APPLICATION FOR A NON MATERIAL AMENDMENT UNDER SECTION 96A OF THE TOWN AND COUNTRY PLANNING ACT (1990) ACT TO REF. 75111/APP/2022/1007 IN CONNECTION TO CONDITIONS 2 AND 10 WITH REGARDS TO:

- **ENERGY CENTRE 2**
- **ENERGY CENTRE 3**
- **CANAL ACCESS RAMP**
- **VISITOR RECEPTION CENTRE 1**

LAND AT BULLS BRIDGE INDUSTRIAL ESTATE, NORTH HYDE GARDENS, HAYES, UB3 4QQ

EC2 Floor Plans & Top View

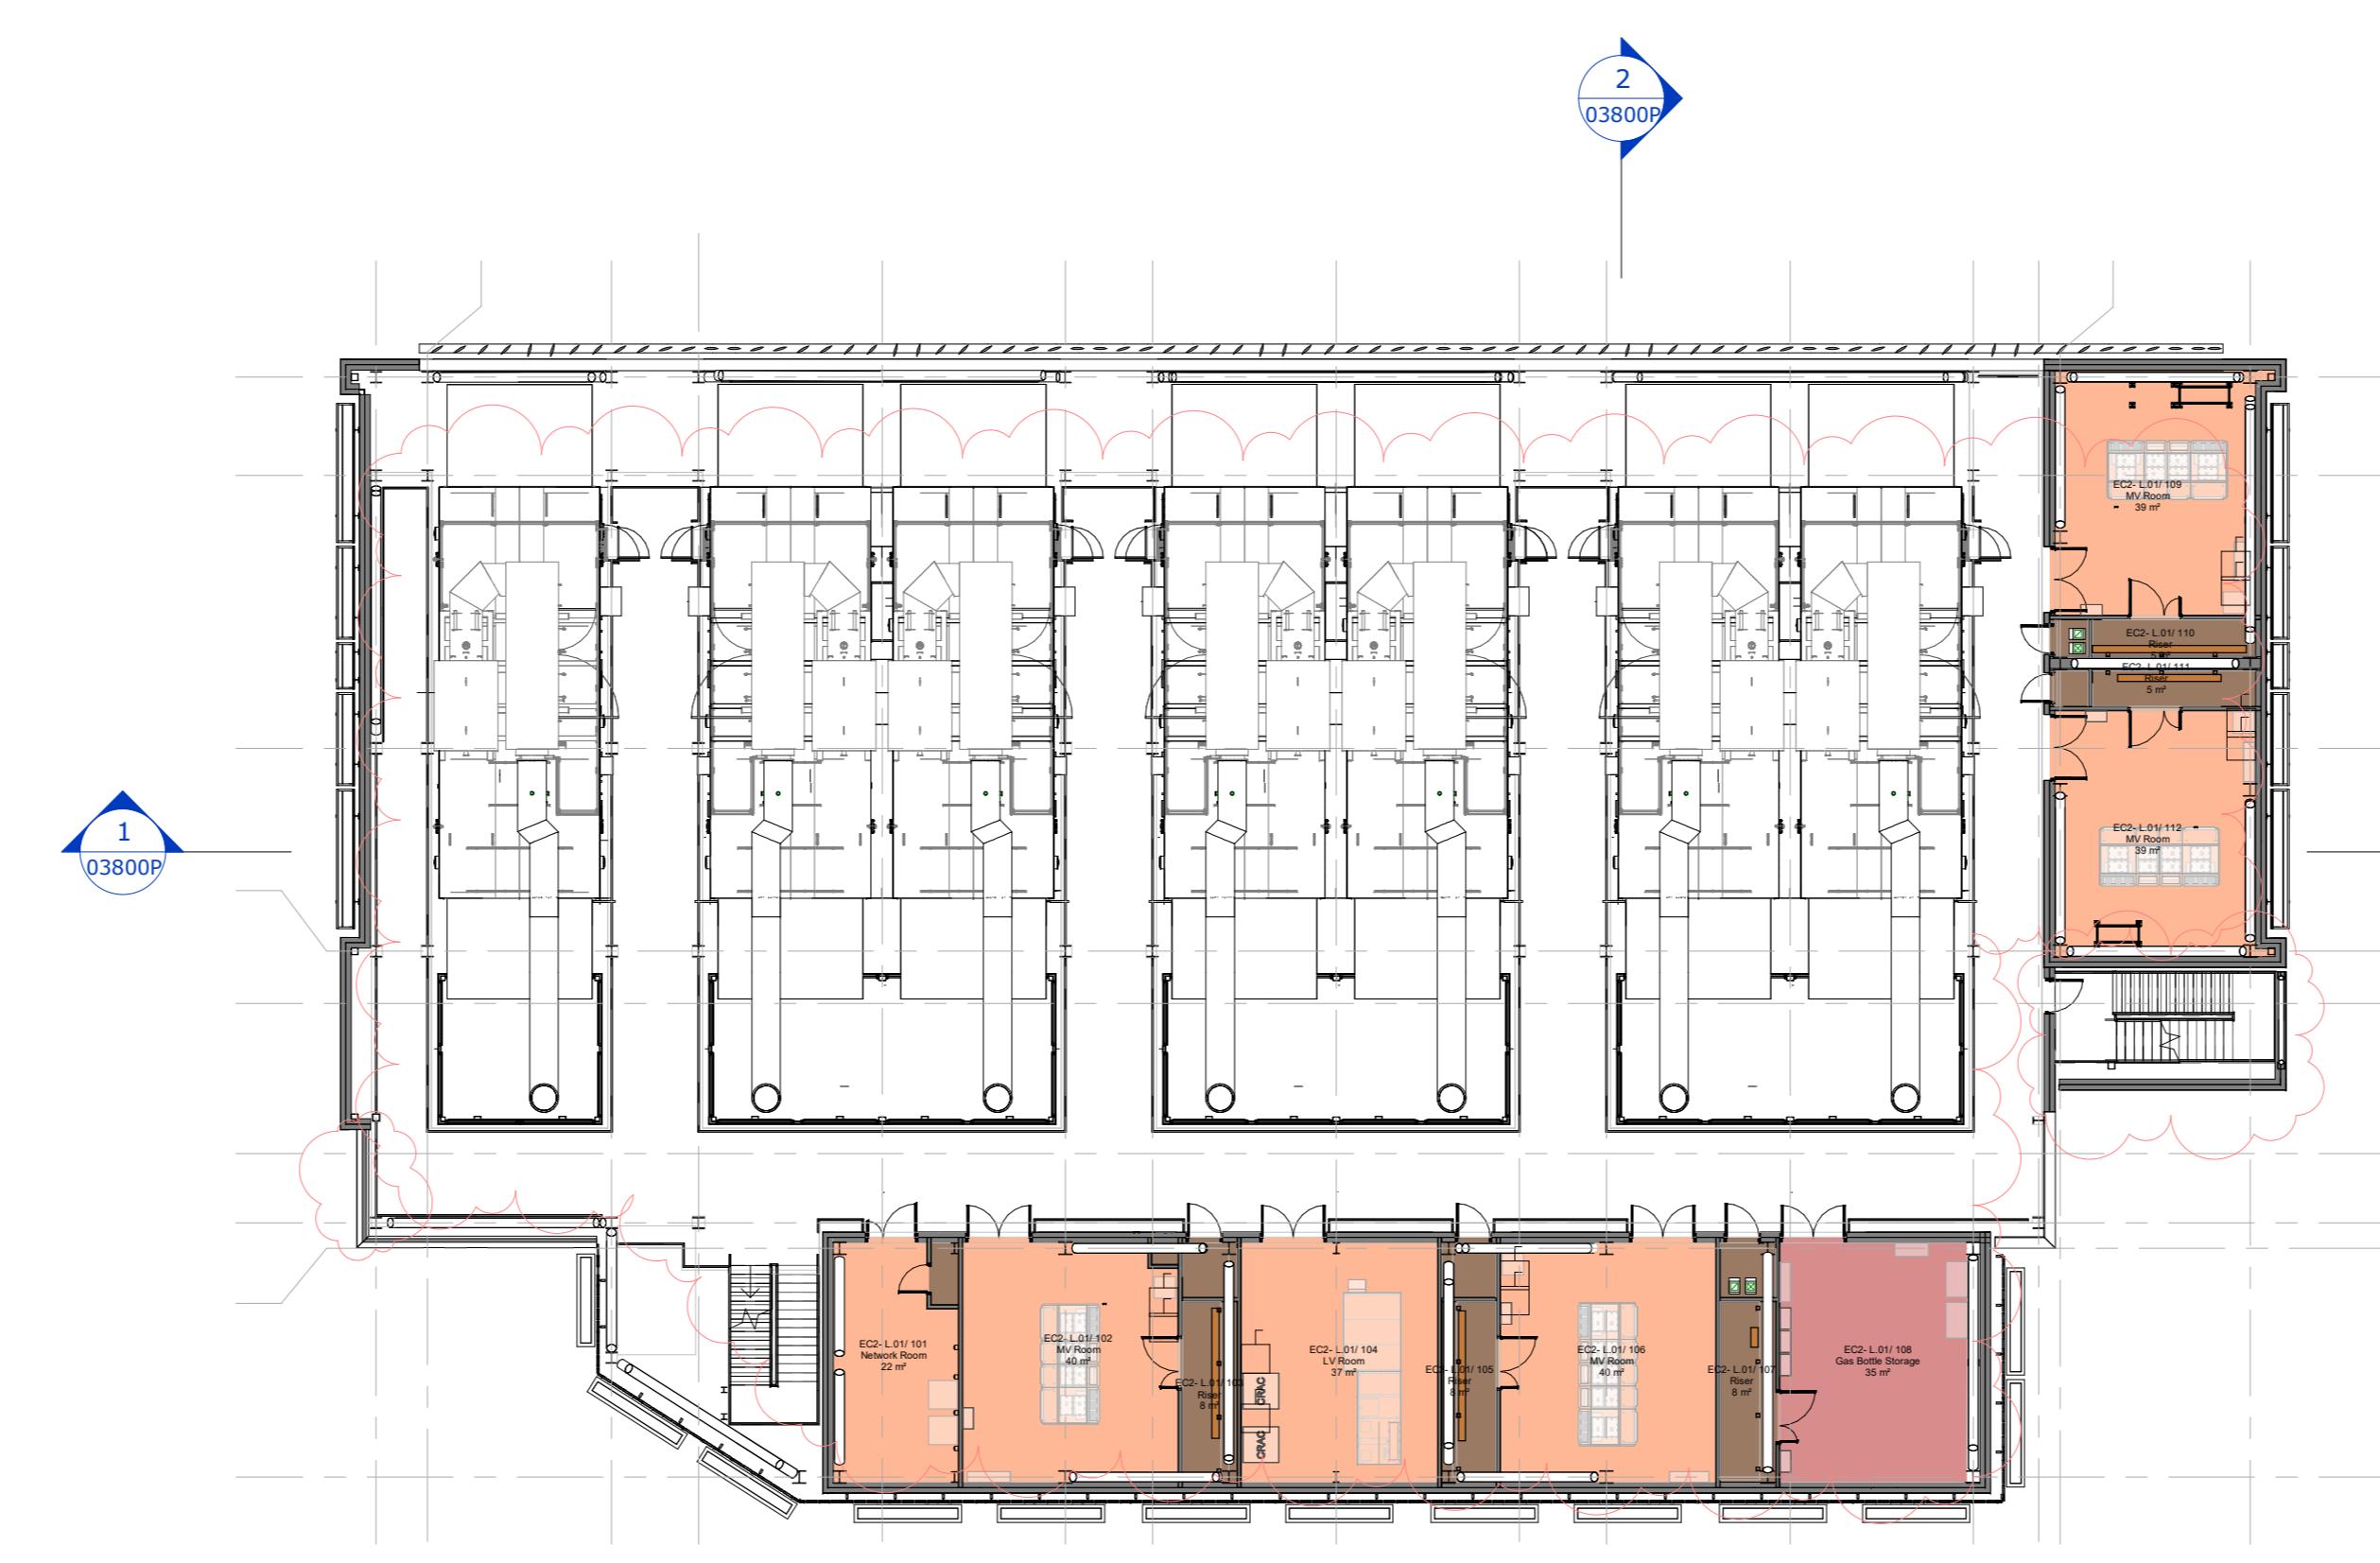
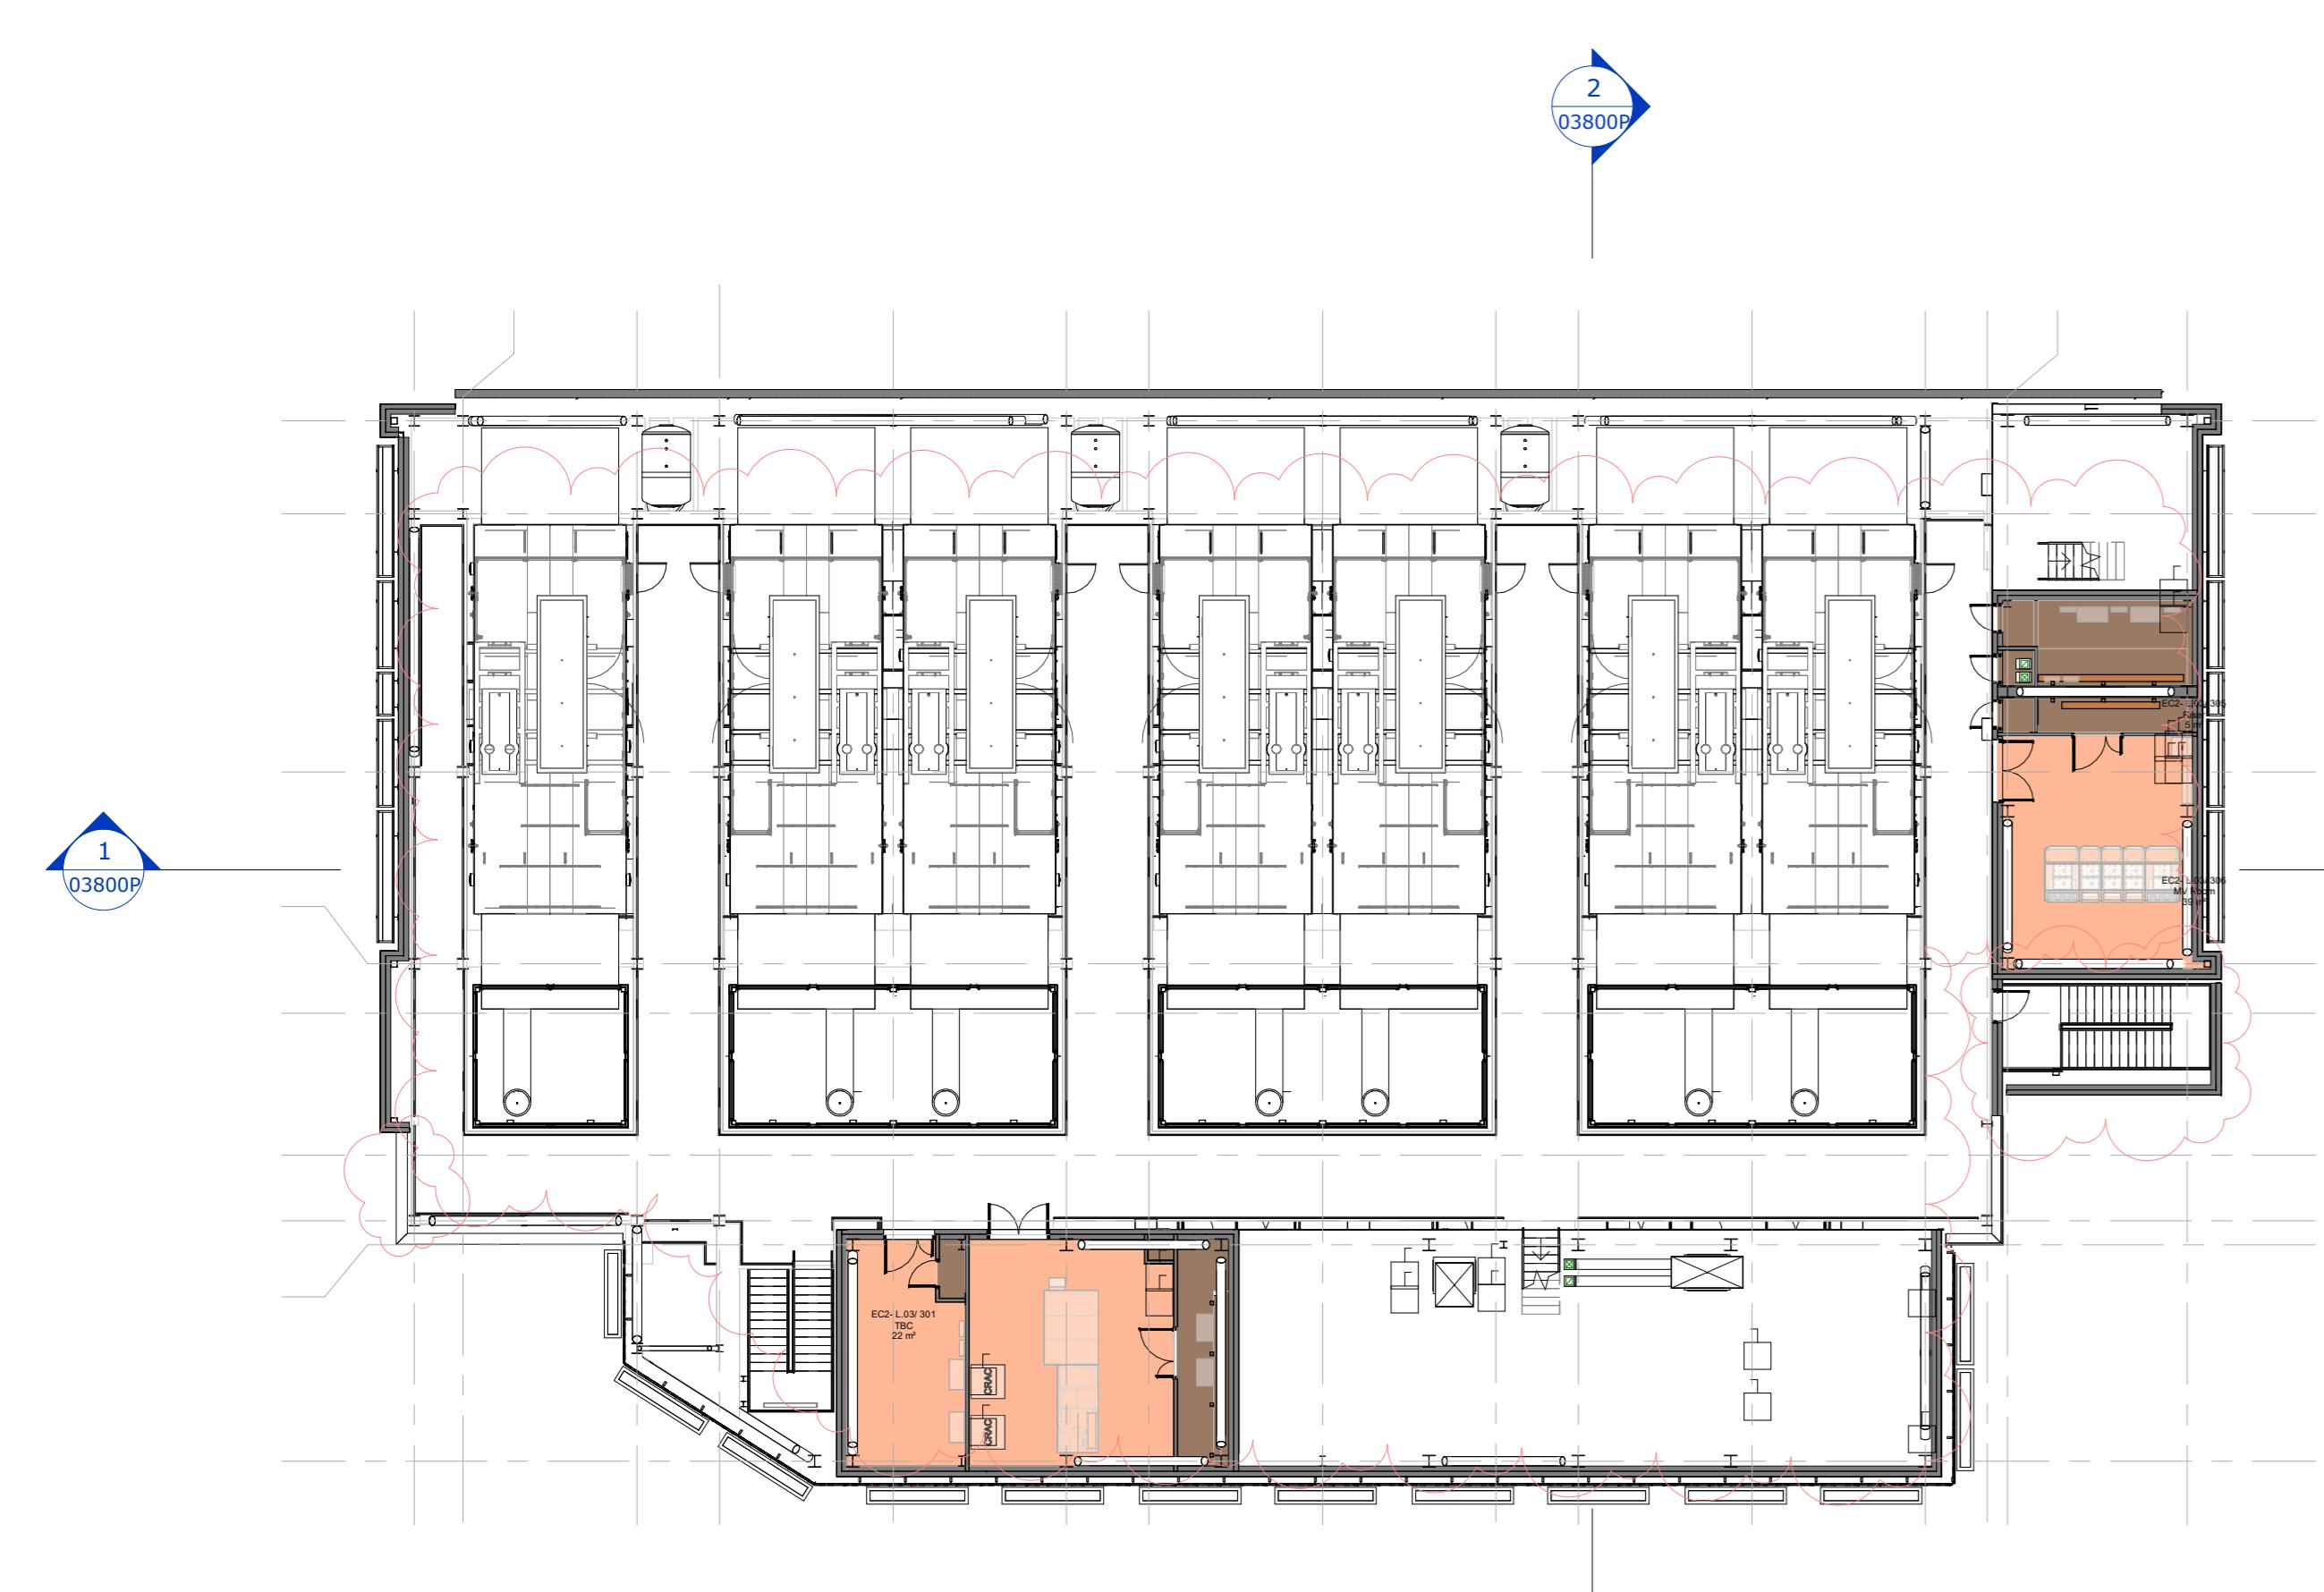
Alteration 1 – Energy Centre 2

The changes proposed to Energy Centre 2 are modest and consist of the following elements:

- Installation of an additional staircase at the southeastern corner of the building. This will be clad in the same materials as the wider building;
- Modest refinement of the footprint of Energy Centre 2 along its western and southern boundary. As shown on the plans submitted, these changes are modest in the extreme and could reasonably be considered to be de minimis;

- To facilitate plant replacement, there is a requirement for the replacement of the brickwork along the northern elevation of Energy Centre 2 with louvres and the replacement of landscaping with planters to facilitate access;

- Reconfiguration of the green wall arrangement along the building's southern and western elevations. Importantly, the quantum of green walling (and the urban greening factor that is achieved) remains unchanged; and

- Reconfiguration of the building's internal arrangement which will mean that the heat rejection stacks will no longer be visible.
